Ribble Valley Borough Council  
Council Offices  
Church Walk,  
Clitheroe  
Lancashire  
BB7 2RA

Phone: 0300 123 6780  
Email: [developeras@lancashire.gov.uk](mailto:developeras@lancashire.gov.uk)  
Your ref: 3/2025/0038  
Our ref: 3/2025/0038/HDC/KW  
Date: 10 December 2025

**Location:** Units 3 3A 4 and 4A Cheetall Farm Clitheroe Road Bashall Eaves BB7 3LH  
**Proposal:** Proposed demolition of existing buildings and demolition of single-storey rear and side extensions to existing barn and conversion of barn to two dwellings with associated curtilage and parking areas  
**Grid Ref:** 371958 441992

Job/Scheme Number		Drawing Number	
0755/93		Drawing No 01A	
Scale	Date	Drawn	Checked
1 / 2500	Sept24	a.t.l-h.

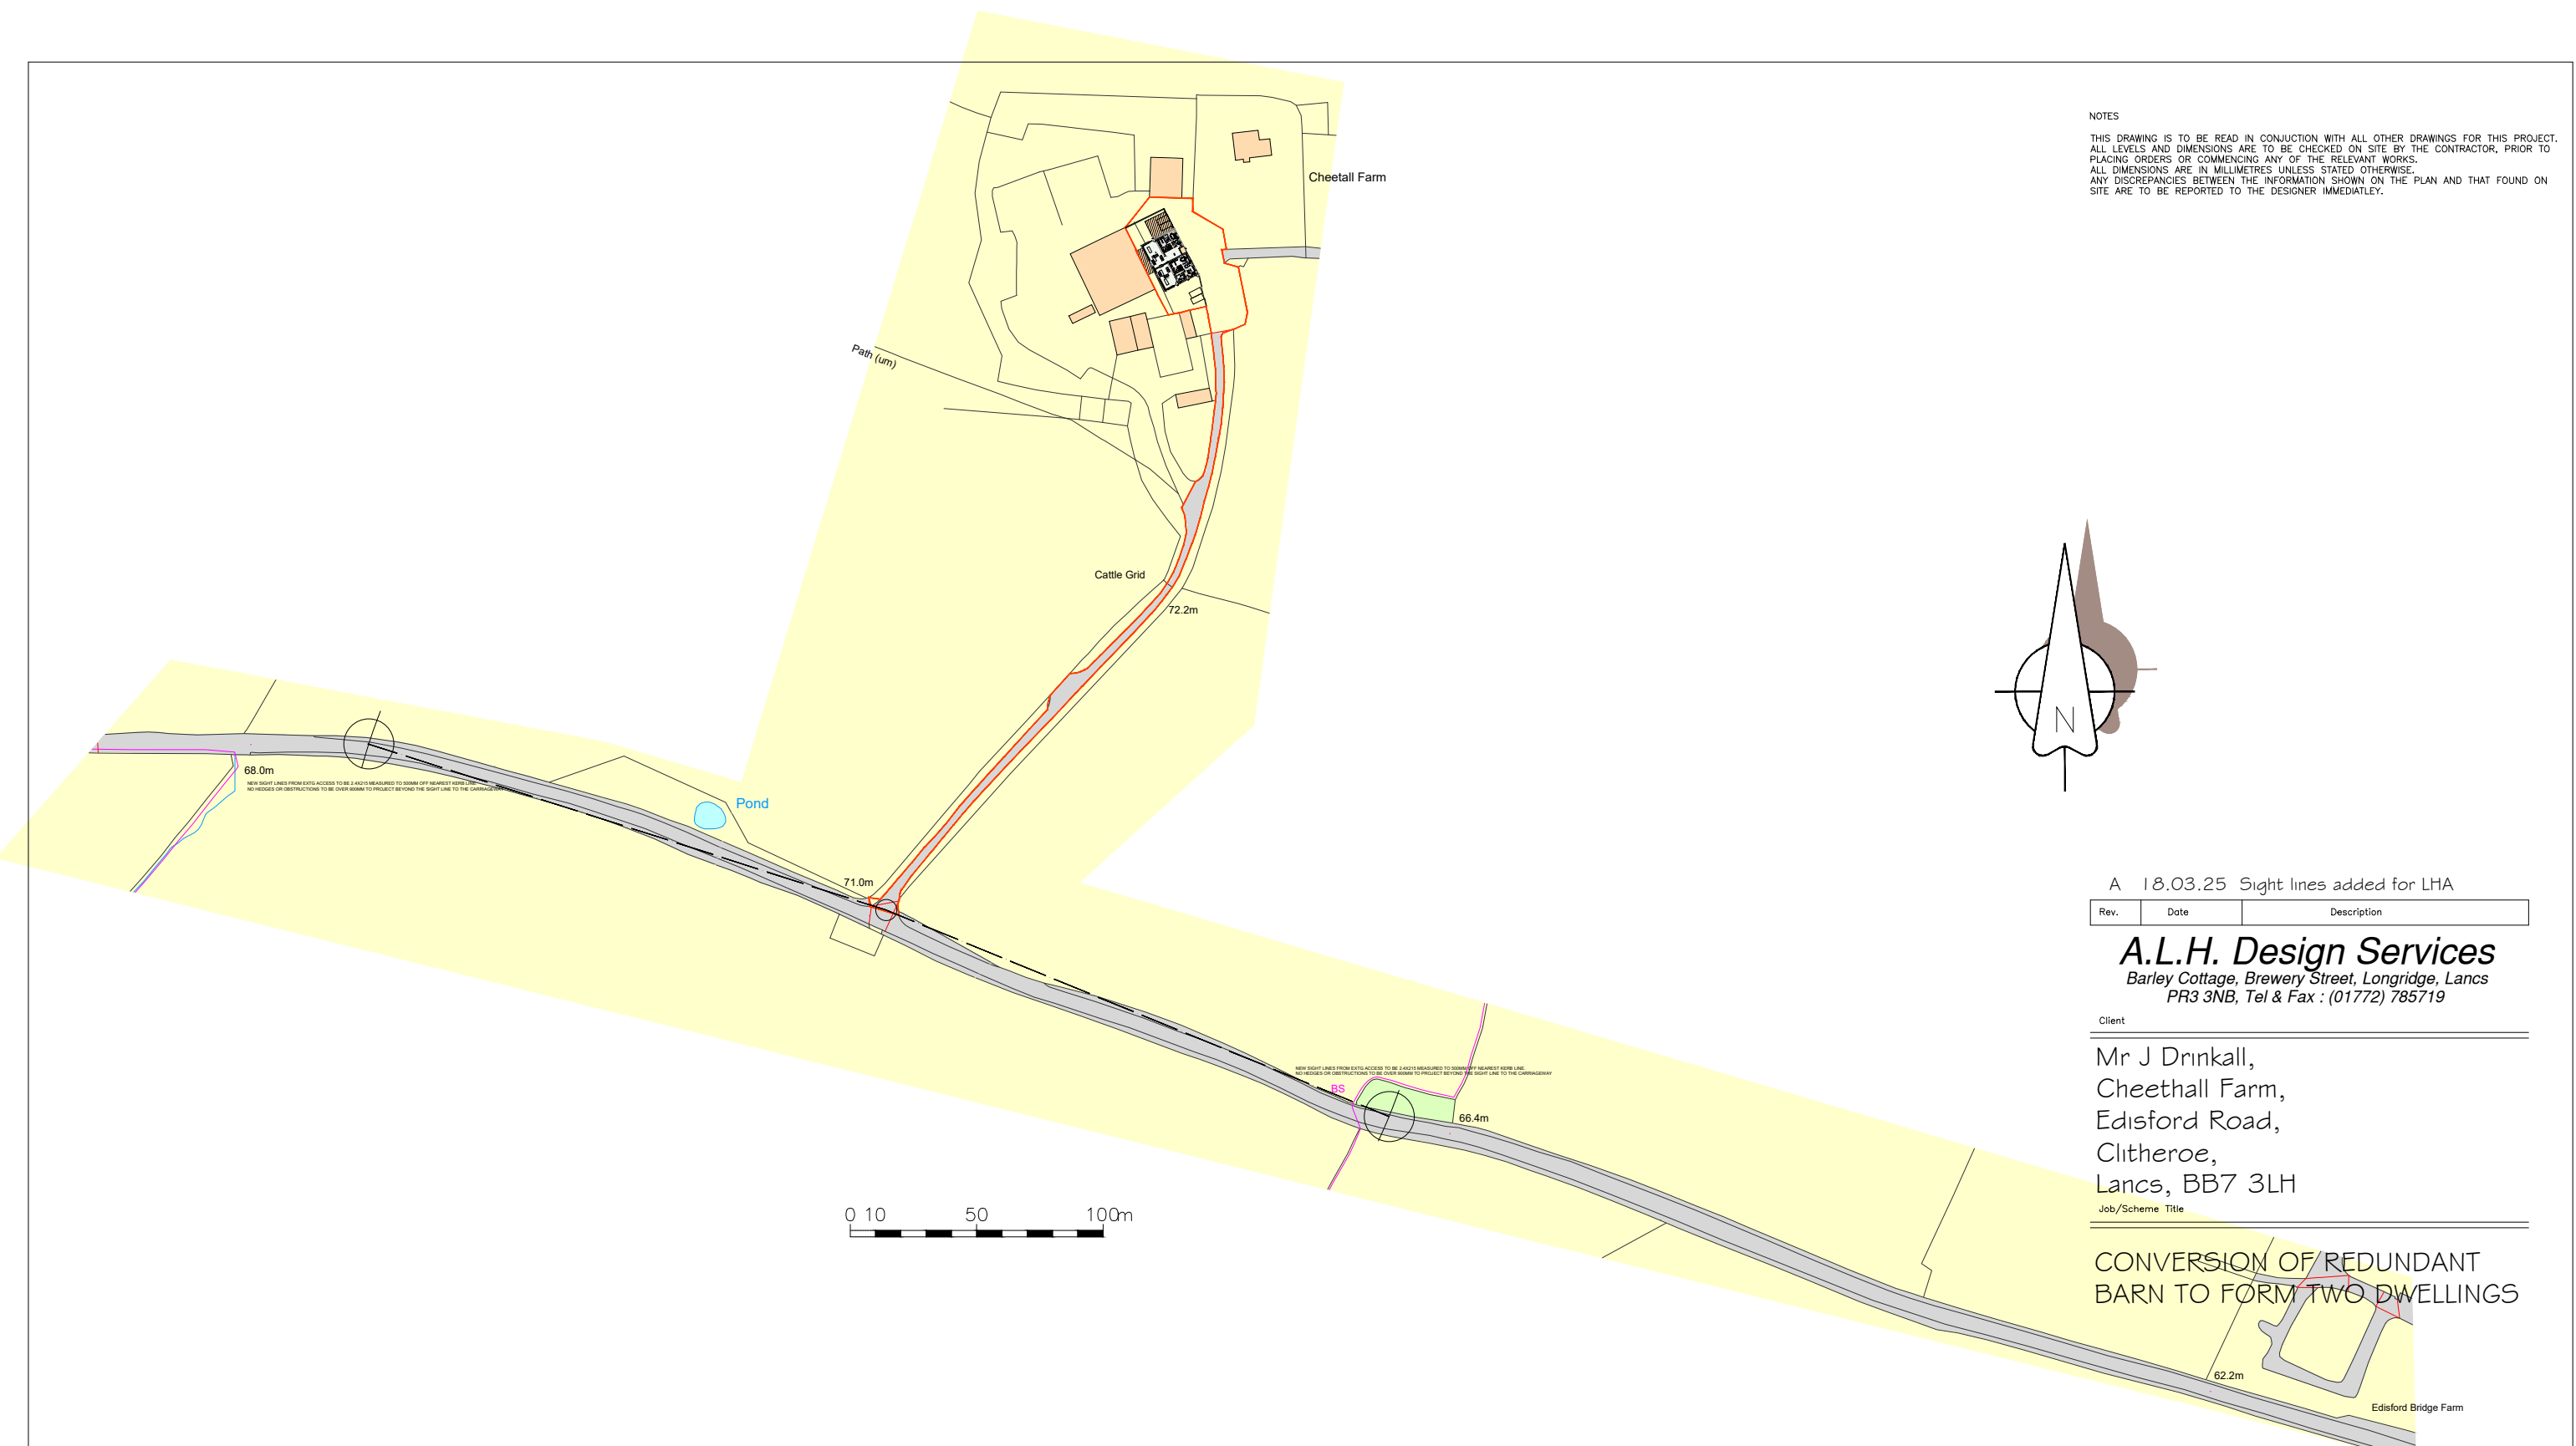
The applicant has also provided a visibility splay within drawing No 0 1A showing visibility splays at the existing access, which meets Clitheroe Road. No vegetation, walls or fences

which fall within the visibility splay shall be above 0.9m above the carriageway level to ensure intervisibility between the access and Clitheroe Road.

Drawing Title
PROPOSED SITE PLAN

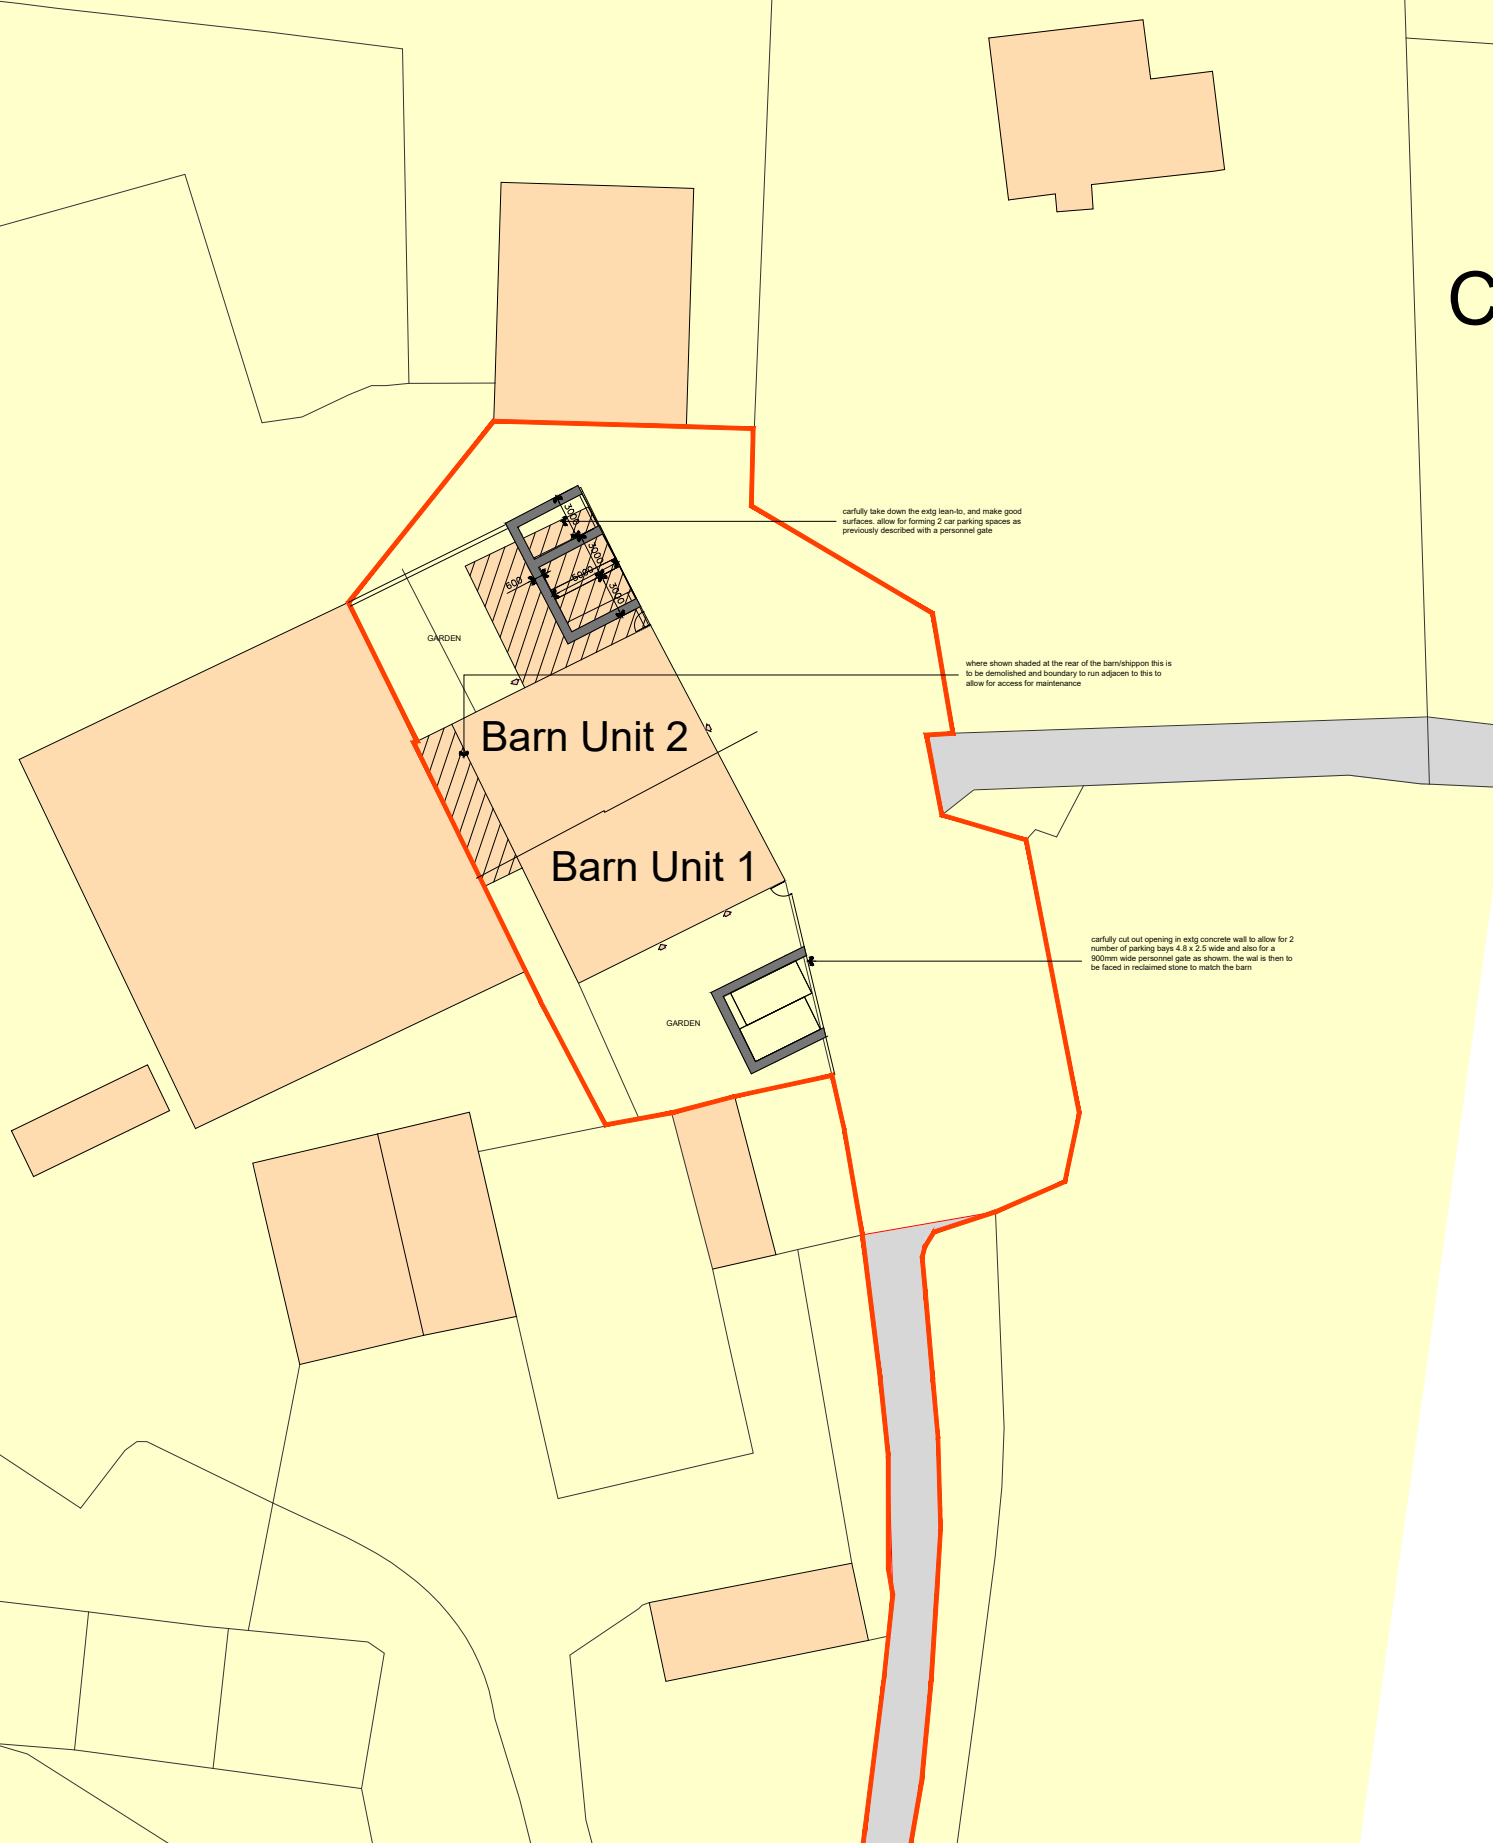
The LHA have reviewed drawing number No 0 8 A titled Proposed Site Plan and note 2 off street parking spaces will be provided for unit 1 and 3 parking spaces will be provided for unit 2 as such the parking provisions comply with the LHAs parking standards as defined in the Joint Lancashire Structure Plan
